Jeanie Bourke - Re: FW: 163 Danforth St., BP#2015-00559 plan review comments

From: Jeanie Bourke [<mailto:JMB@portlandmaine.gov>]
Sent: Thursday, April 23, 2015 1:18 PM
To: Oscar Verest
Subject: 163 Danforth St., BP#2015-00559 plan review comments

CONSERVATORY INSULATION

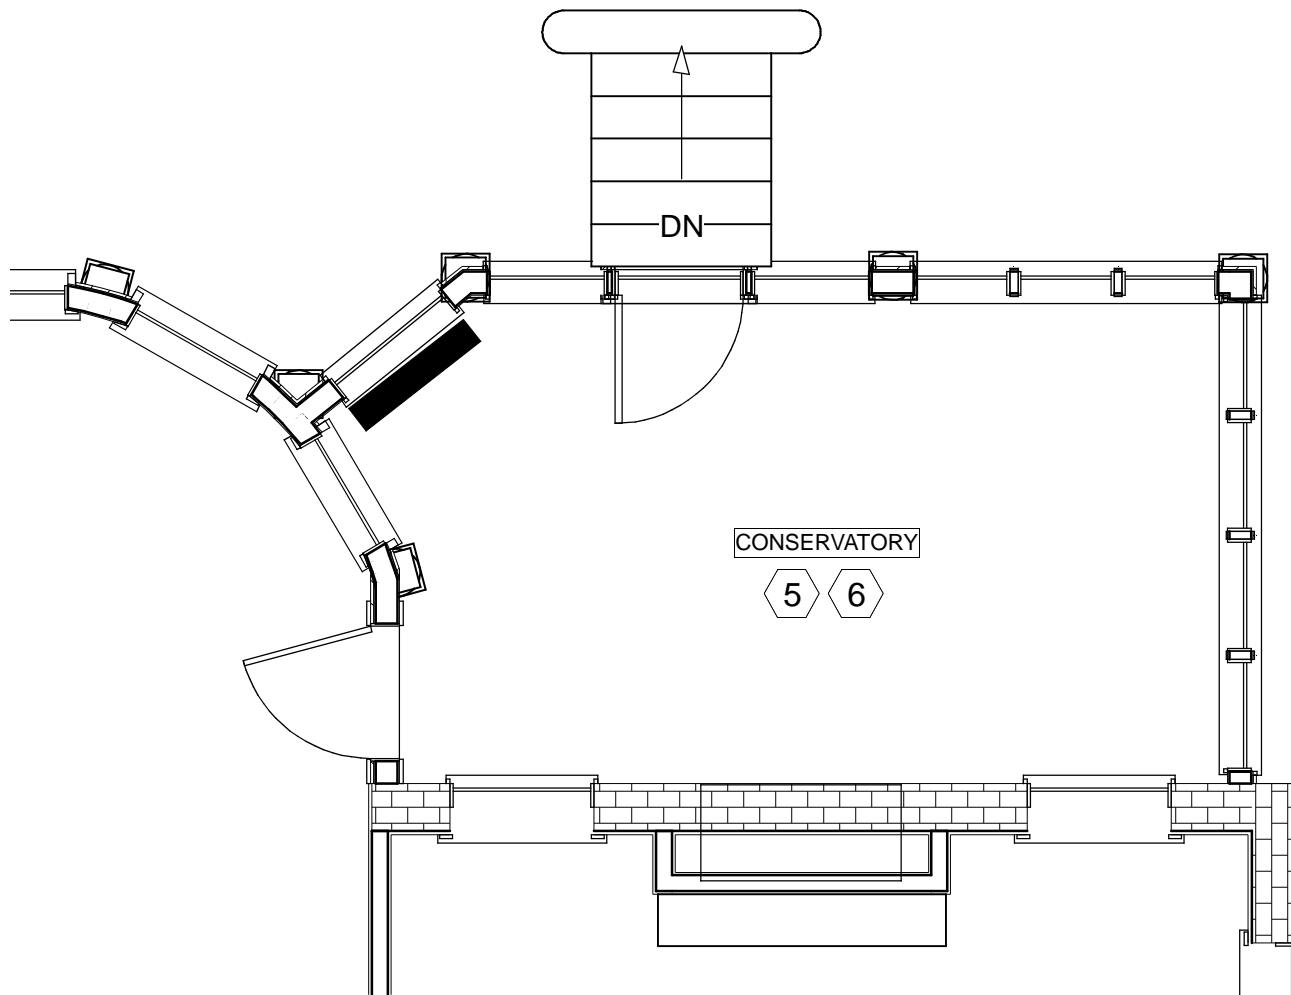
- The kitchen ceiling will be insulated with R-29.6 Icynene Open Cell Spray Foam Insulation LDC 50-bin (per conversation of Alex with the fire dept, which is registered on your site for the building permit application) and 5/8 fire rated sheetrock.
- Floor finishes is tile from Distinctive (12x12 Formations Flint, see enclosed). It is the same tile that is being used in the kitchen of Hugo's.

Thank you for the information, I will approve the permit, you will be contacted shortly when the permit has been prepared for issuance.

1 SK1 KITCHEN AREA DEMOLITION PLAN AND NOTES
SCALE: 1/4" = 1" - 0"

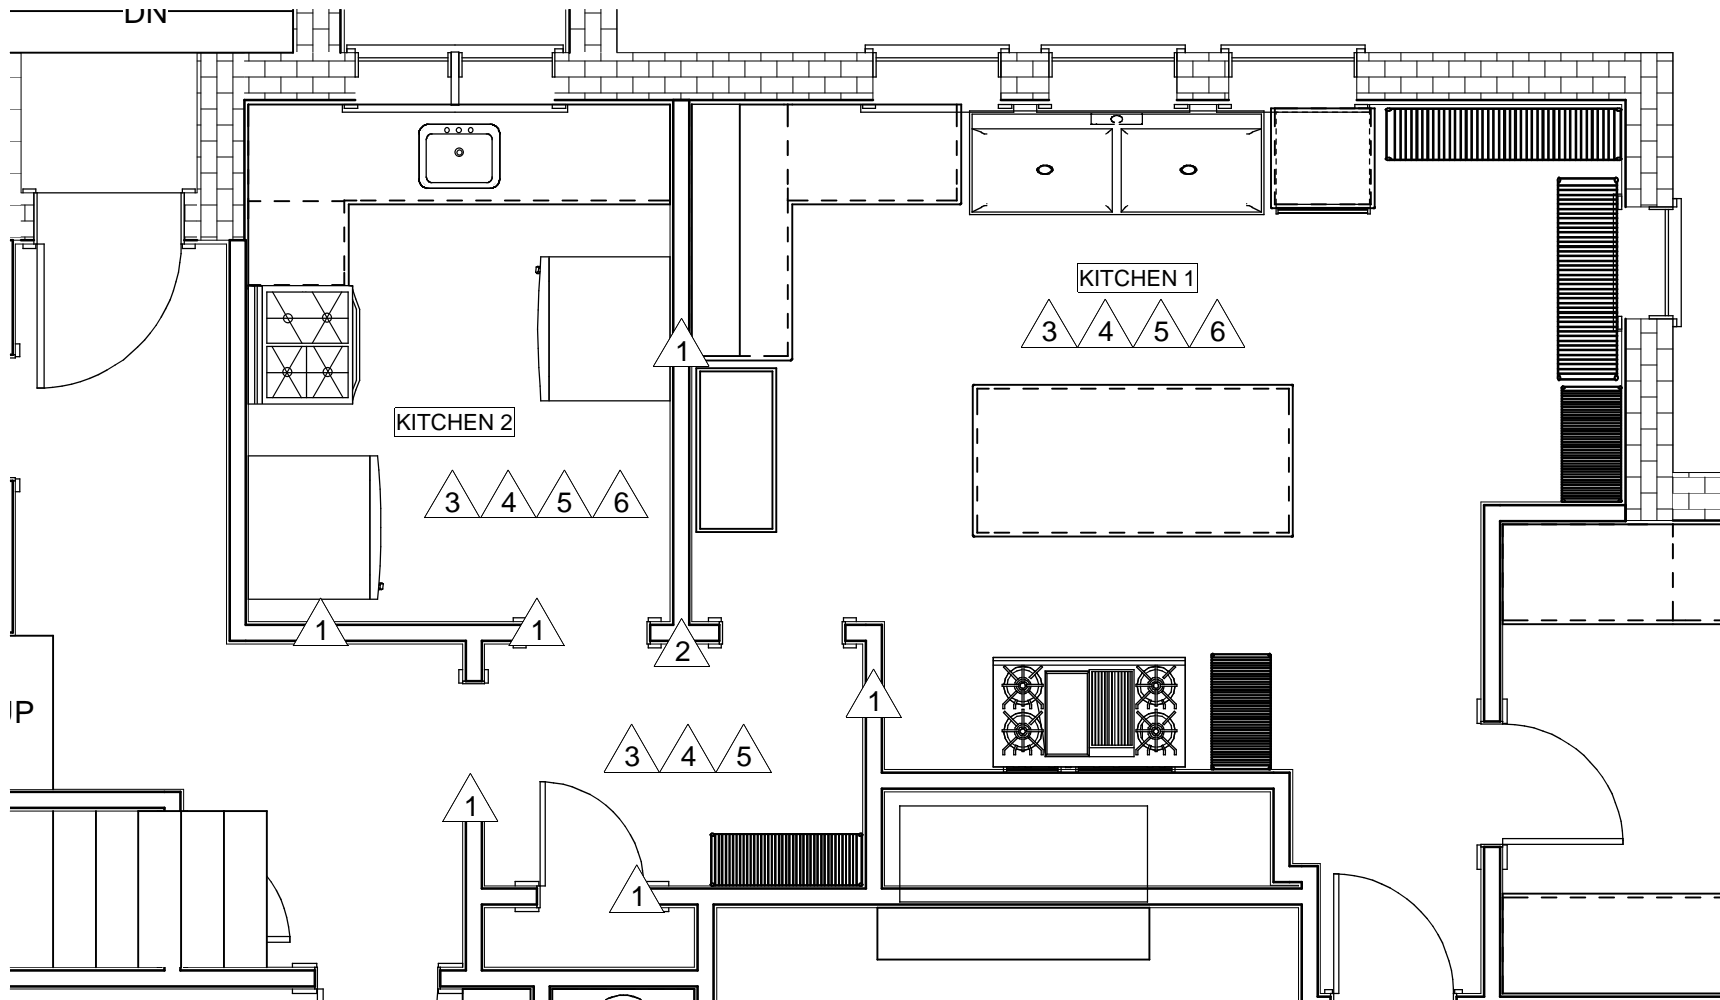
- The hood and its ductwork will be renewed in accordance with the regulations in Portland. Dick Desrosiers from Mid-State Sheetmetal will be doing the installation. He has done installations for Portland restaurants and is familiar with code. See enclosed his comments (please discard the fact that the letter says estimate).

As discussed with Deb Andrews and with officer Chris Perone, we will use the current exhaust in its current location and renew all ductwork (sufficient thickness) and get a new hood to make it up to code. The window above the exhaust fan will be fixed, so it won't be able to open to meet code. As discussed with the Historical department (and approved) late last year, we want to move the exhaust to the roof of the building in the future. As we are getting close towards the season, we will move this to next winter/spring, as that will be more invasive for the 2nd floor part of the building. The historical department has given us 2.5 years to do that, but we anticipate doing that within a year, while we are still working on financing for that part.
